Date 4/04/2019
To Katelyn Symington (Department of Planning and Environment),
Kelly McNicol (Department of Planning and Environment)
From Sean Fishwick (Arcadis)
Copy to Jordan Rodgers (Sell and Parker), Westley Owers (Arcadis)
Subject SSD 5041, Modification 3 - Response to Submissions

Sell and Parker (the Applicant) currently own and operate a metal recycling facility at 23-43 and 45 Tattersall Road, Kings Park (The Site). The Site currently operates under approval SSD 5041 (the Original Approval) and two associated modifications (the Project). Due to recent changes in market and policy conditions including the introduction of China's National Sword Policy have resulted in the need to Modify the Original Approval (the Modification Proposal). To respond to these changes, the Applicant proposes to modify the following elements:

Figure 4 | Proposed Modifications to the Approved Site Plan

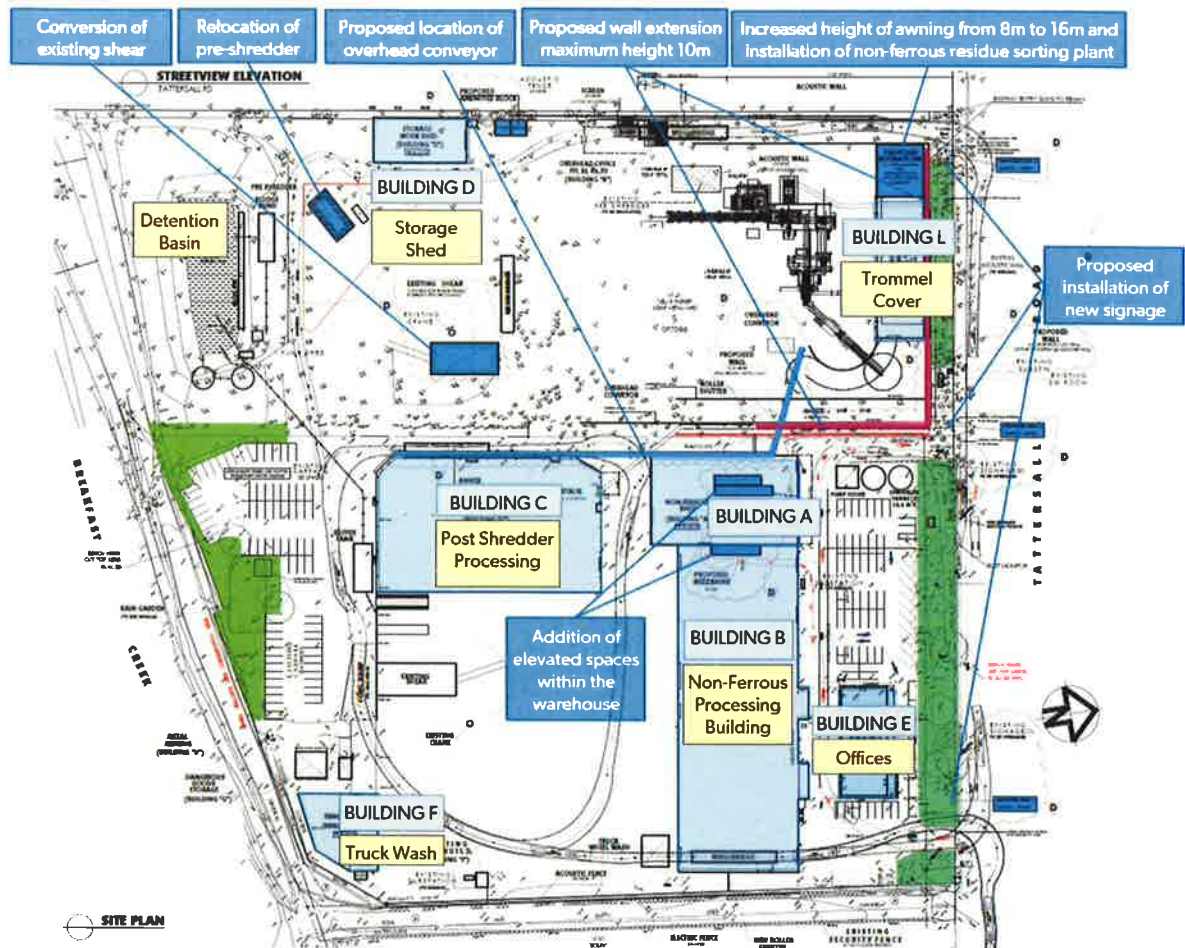
The site plan indicates that 3 signs at gates A, B and C are proposed to be constructed in our nature reserve along Tattersall Road. This is not supported and all signs are required to be constructed wholly within the property boundary.

The proposed signage at gates A, B and C have been incorrectly shown within the Engineering Plans (Appendix B of the Modification Application) to be within the Council nature reserve. As shown within the updated Engineering Plans (Attachment A), all signage would be located wholly within the site boundary.
